FISHERS CANYON CREEK
CHANNEL IMPROVEMENT PLANS
EL PASO COUNTY, COLORADO
GENERAL NOTES

PROJECT NO.
196825001

TRIBUTARY - PLAN VIEW  
STA. 58+00 TO 54+00

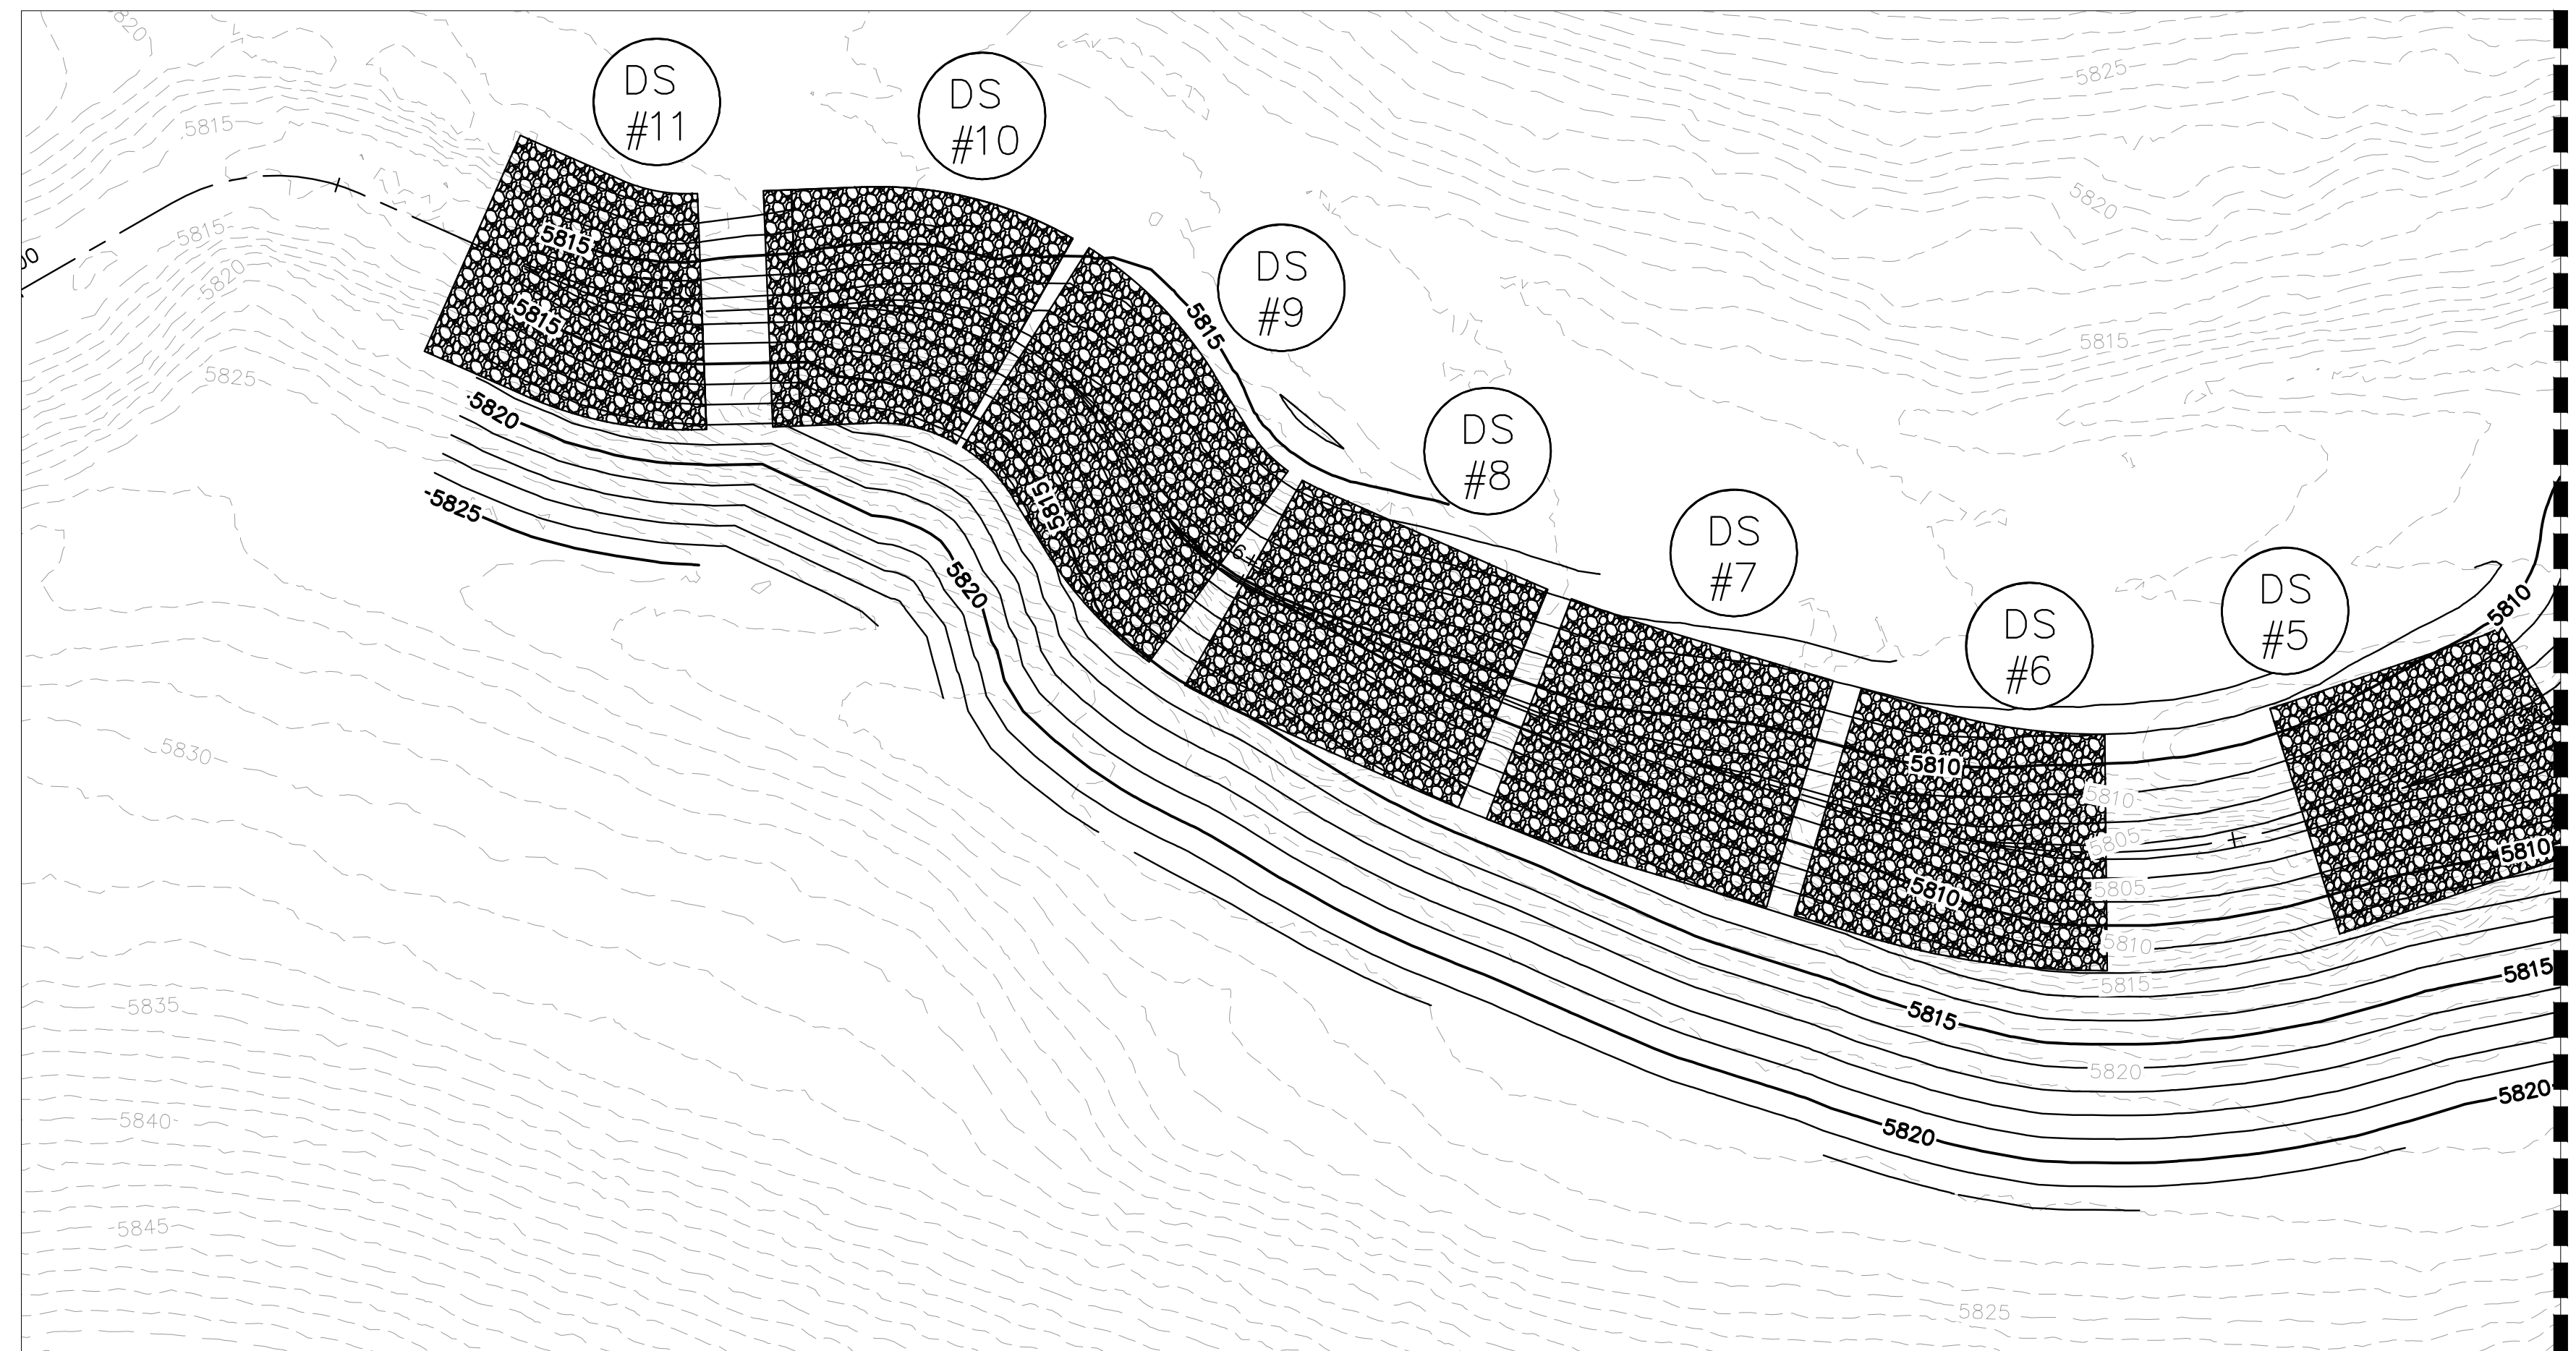
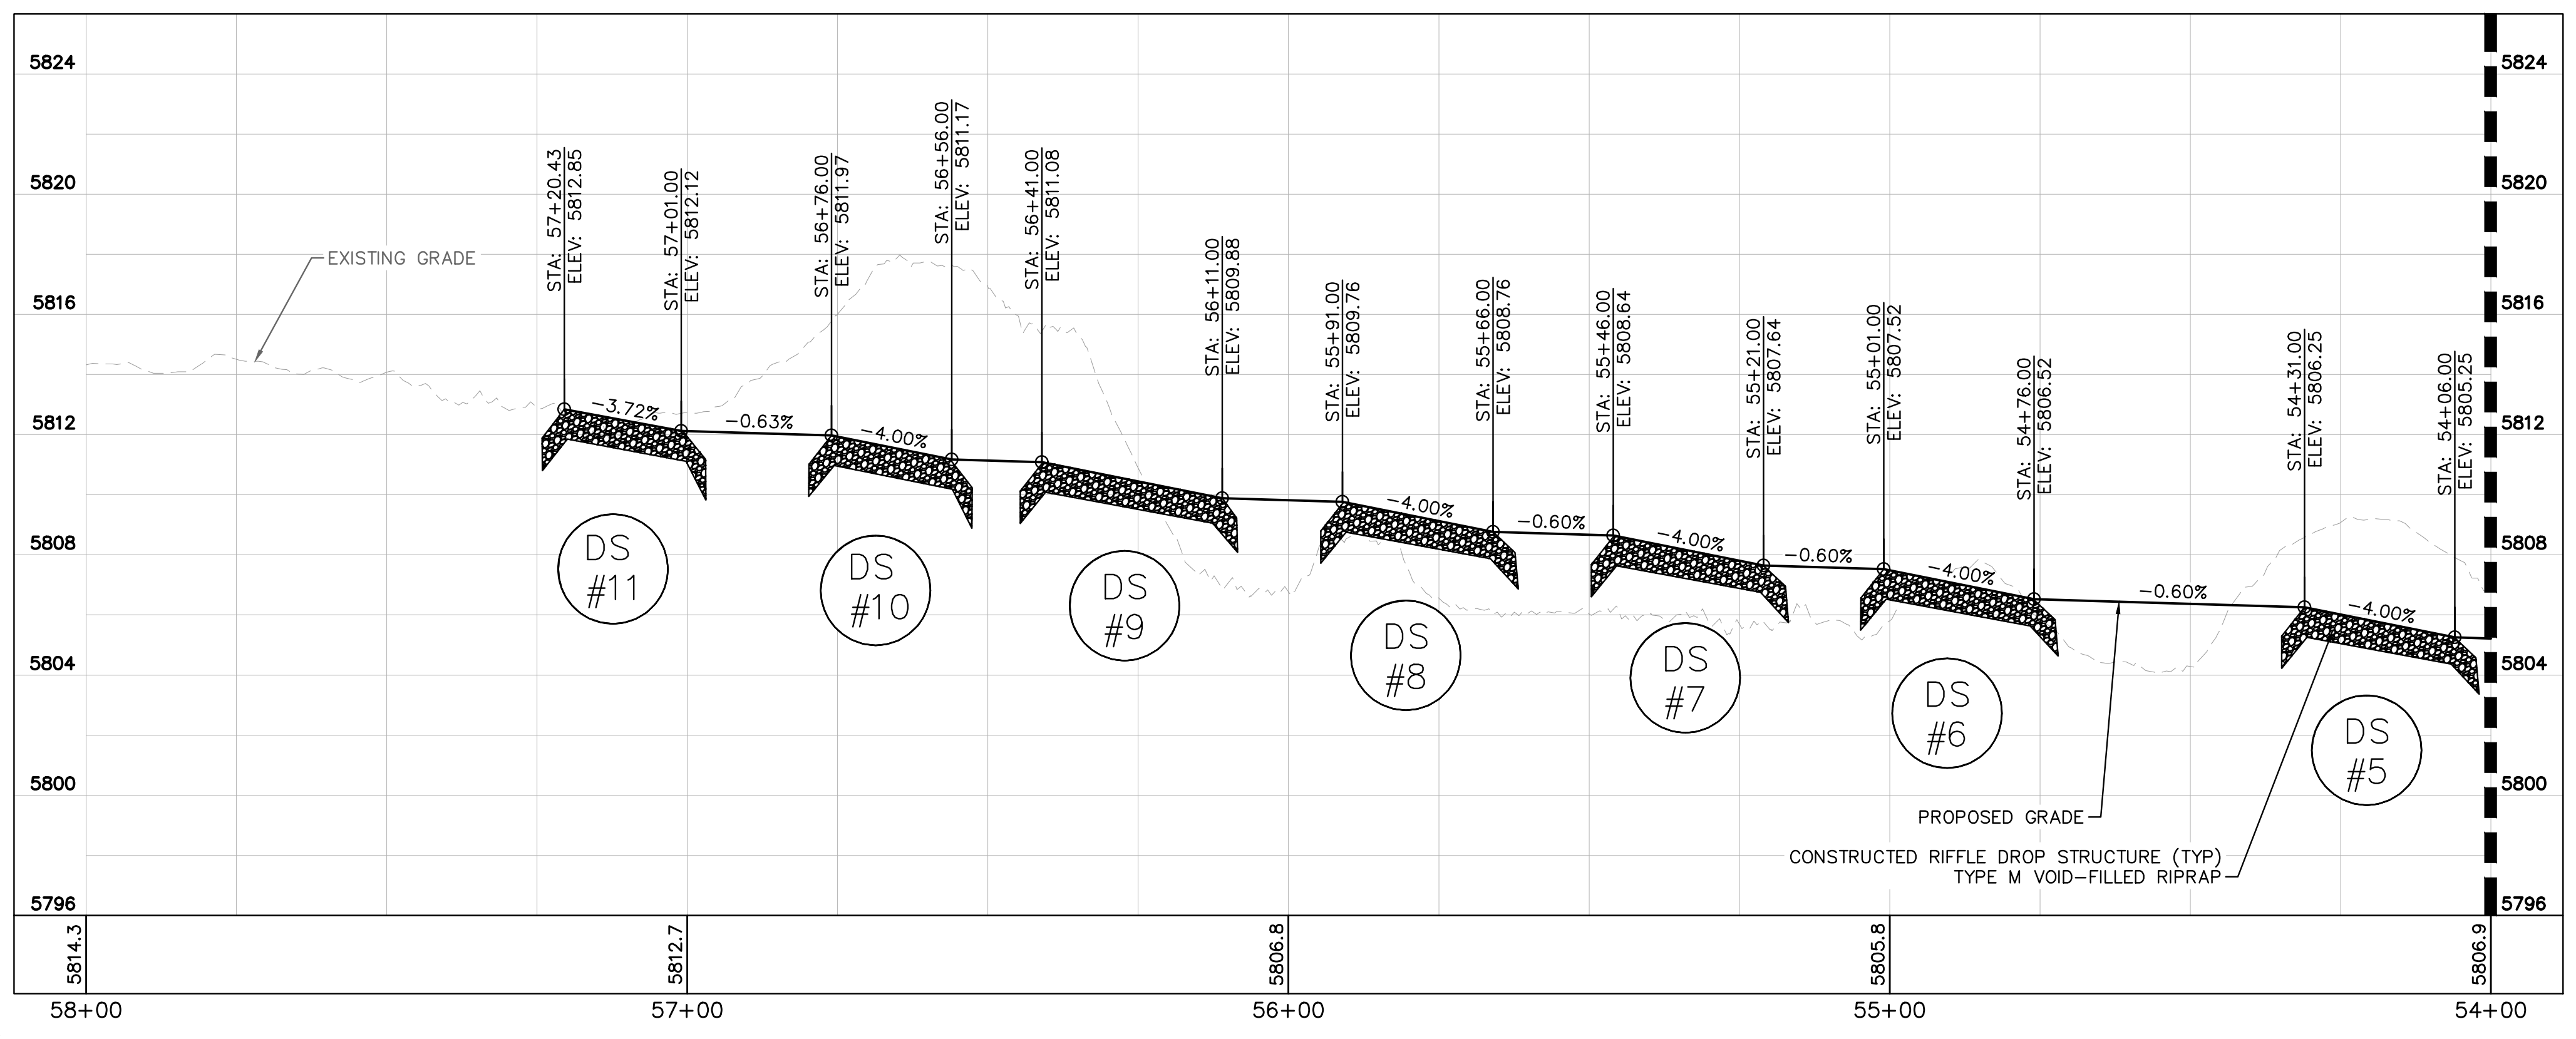
Please add HEC-RAS stations and channel alignment stations on these P&Ps or another sheet for correlation

Address locations where low-flow and full-width cutoff walls (one option shown) may be required

label each grade also, why not continue riprap material in between the riffles
